22 FREE STREET

Thanks for working through this with me and answering my questions last week. Please find attached revised documents addressing your previous comments for clarification:

AD.101 - 22 FREE STREET DEMO FLOOR PLANS
A.101 - 22 FREE STREET PROPOSED FLOOR PLANS

1 MAIN LEVEL - PROPOSED FLOOR PLAN
SCALE: 1/4" = 1'-0"

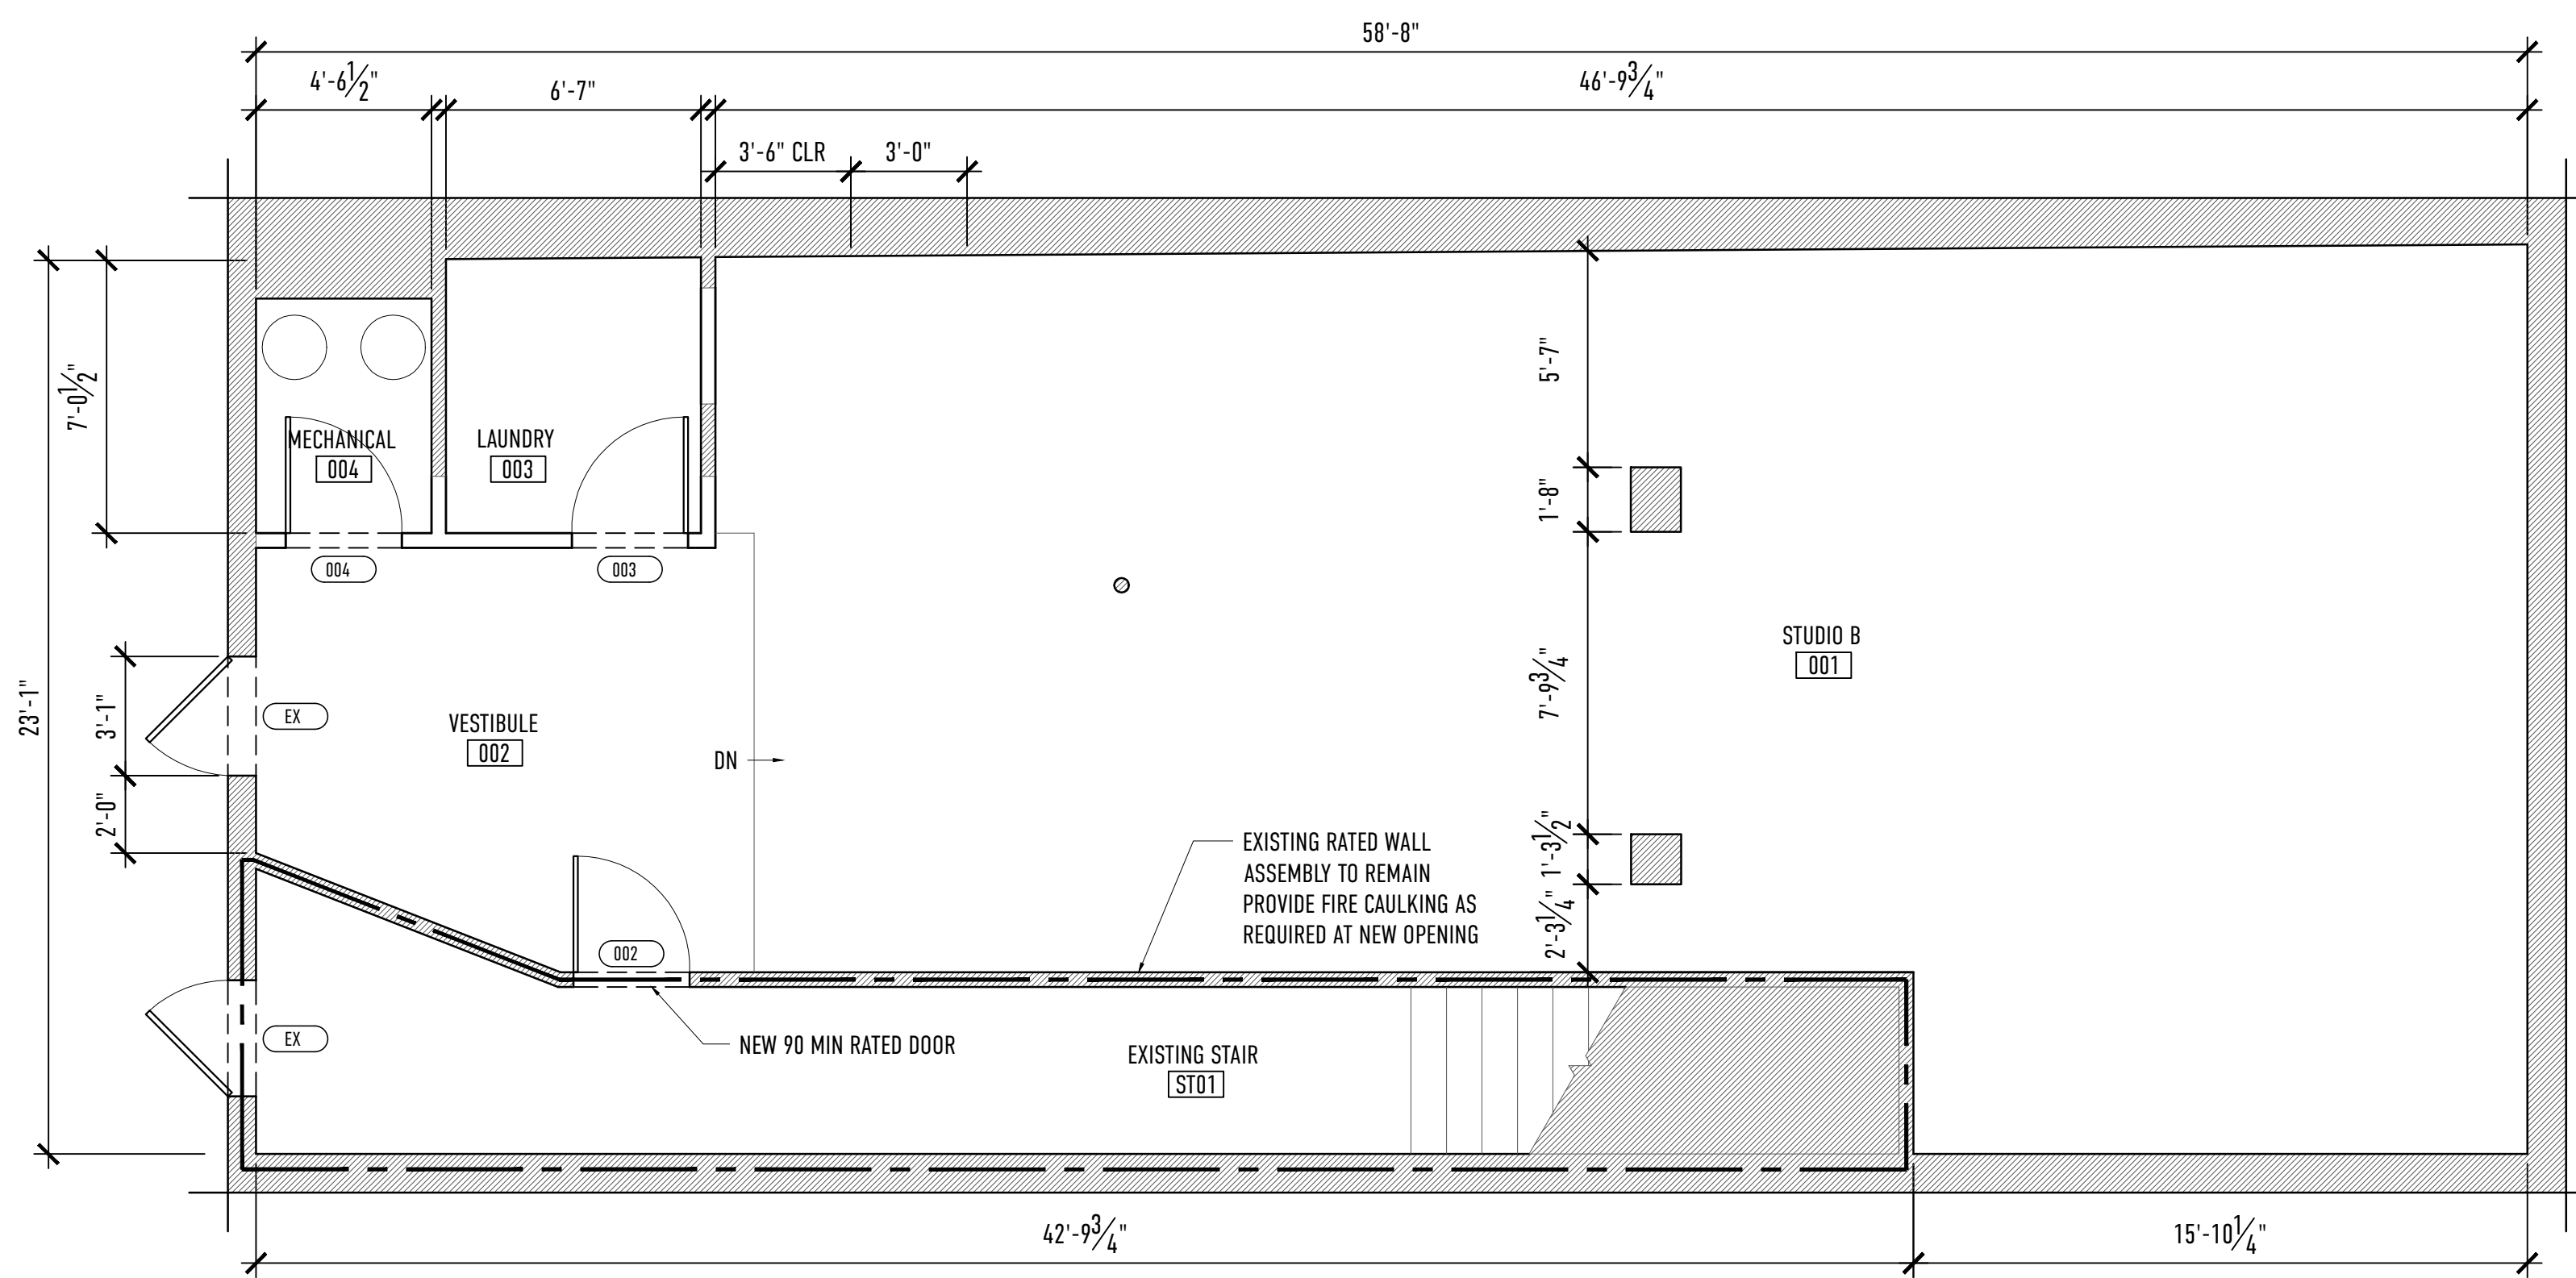
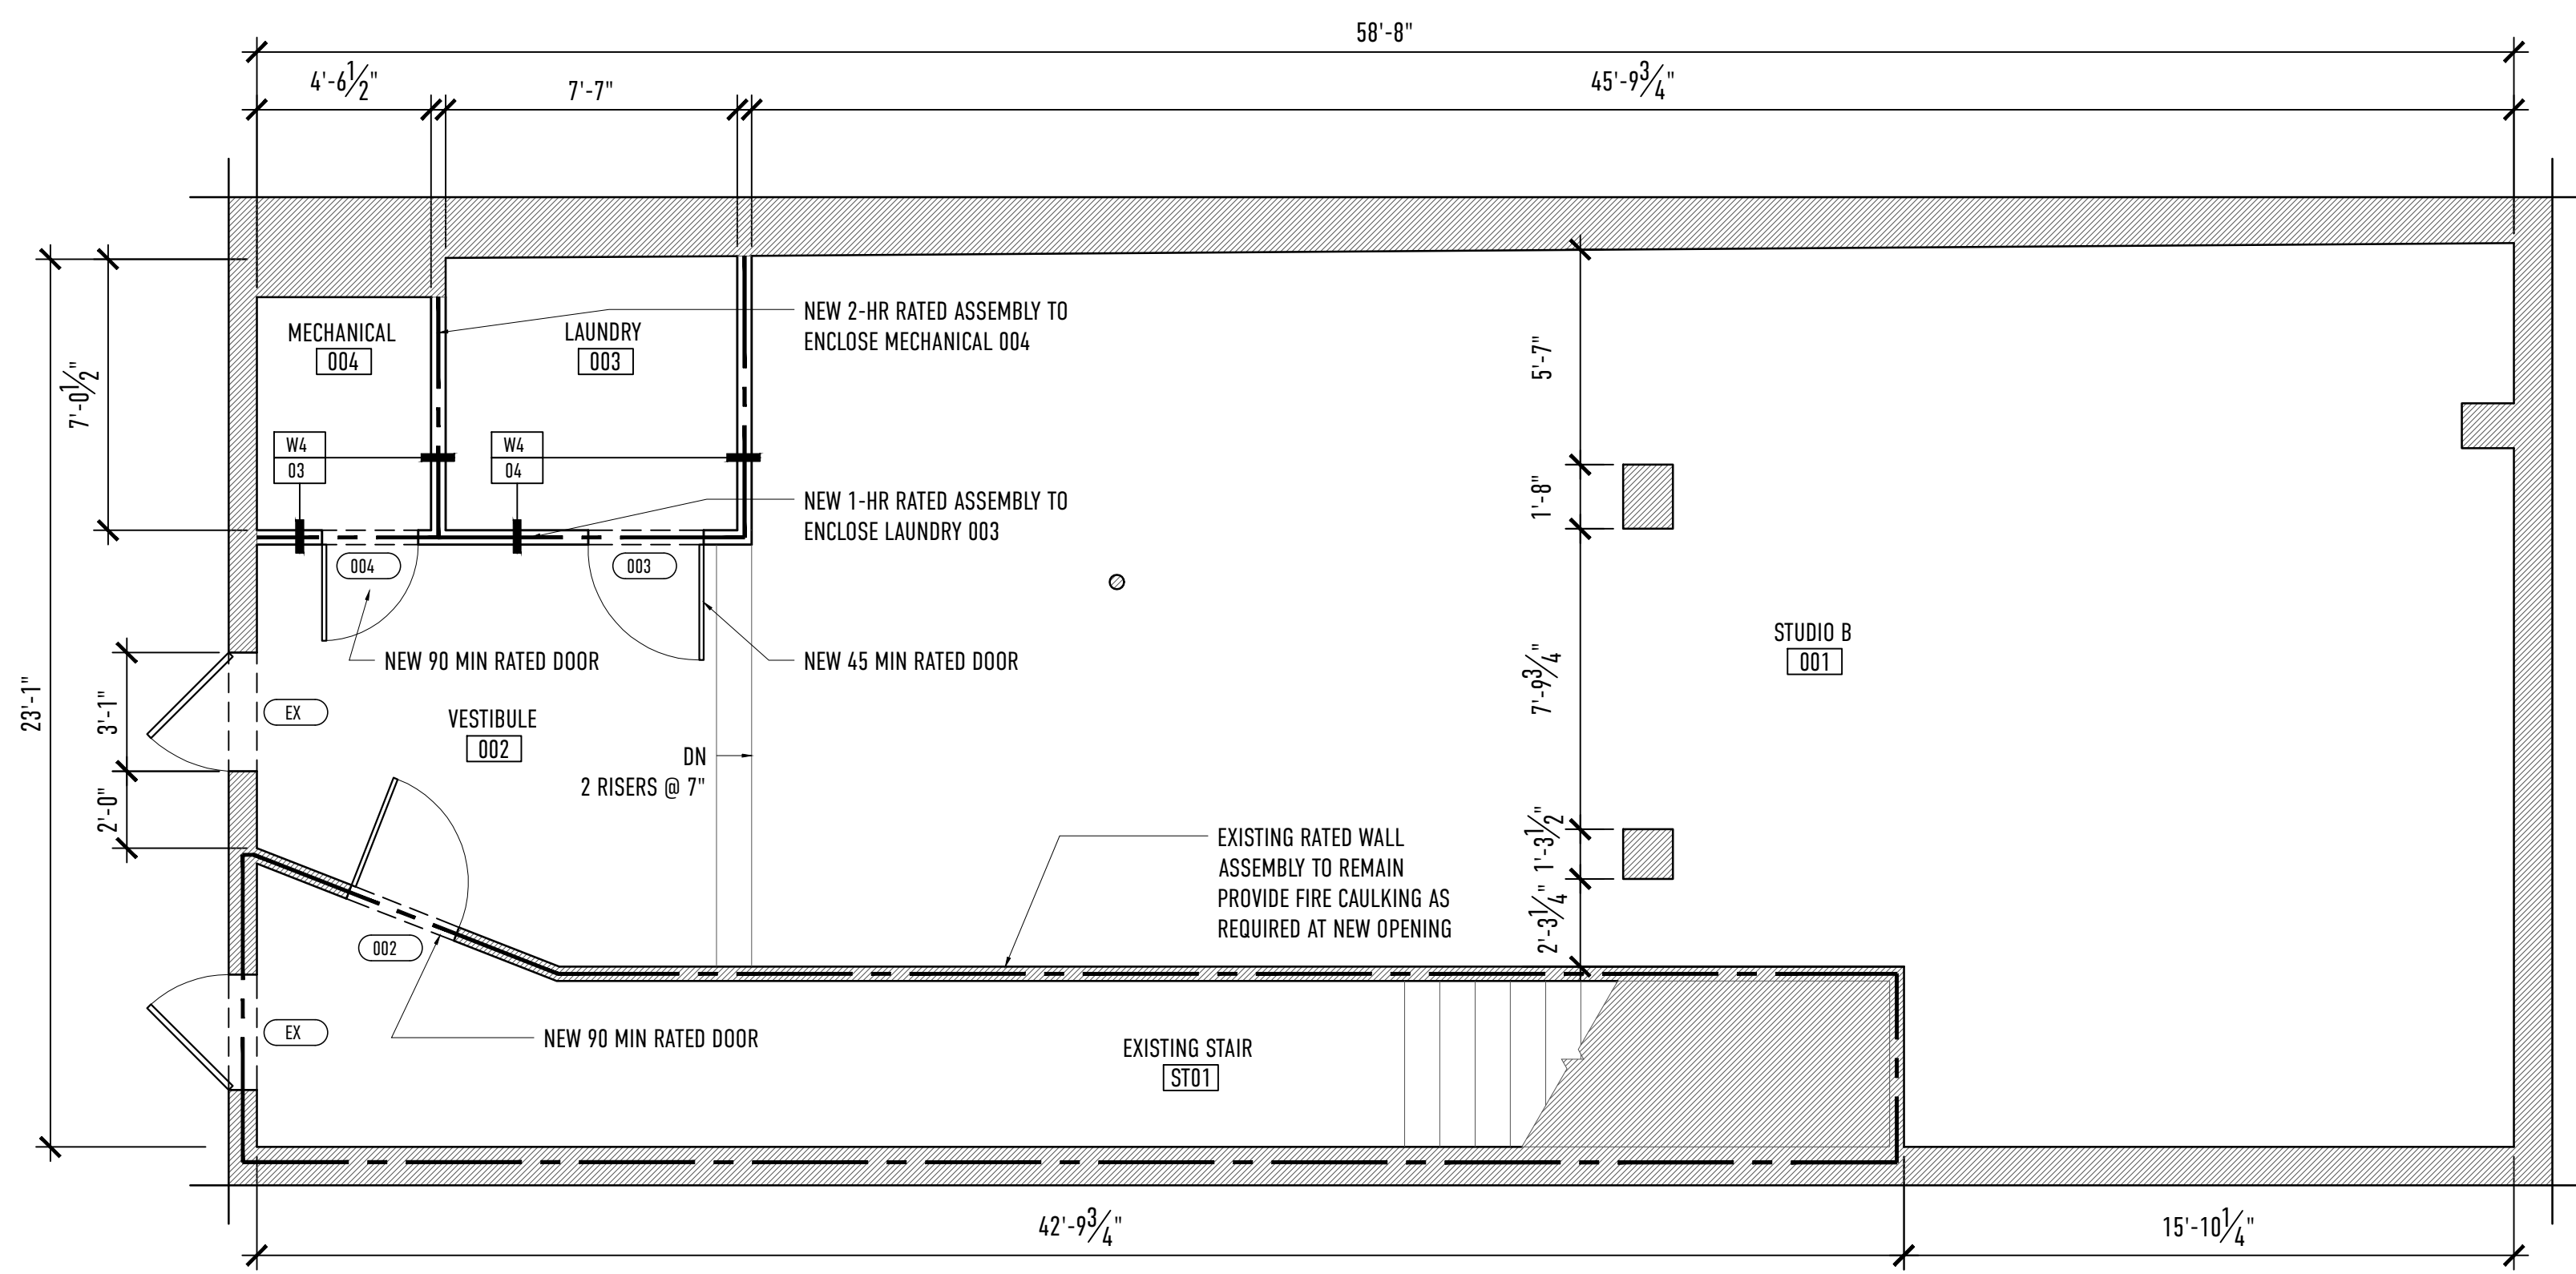
A.101 - MAIN LEVEL:

- Fold down seat? We were not intending to use a fixed fold down seat, we have therefore included grab bars on (3) sides with a removable seat per fig. 608.3.2 (a) - Grab Bars for Standard Roll-in Type Showers.
- How is plumbing vented? See 'General Notes'
- Door swings over clearance/does this stall comply with ADA 2010 section 604? Bathroom stalls in Women's Locker RM 103 have been revised per ADA compliance.
- Skylight section with framing details: skylight is existing - note has been updated on plan with no proposed changes to existing framing.

A.101 - LOWER LEVEL:

- Unassociated dimensions have been removed.
- Any fuel burning equipment/what is the proposed HVAC system? Mechanical 004 was originally intended to house electric hot water heaters for locker room above. Owner has since installed a new fuel burning system dedicated to an adjacent unit. This area will be enclosed by a 2-hr separation as indicated on plan, with a new 90-min rated door. See 'General Notes' for further information on HVAC.
- Height of step? Plan has since been revised with (2) risers @ 7" in height.
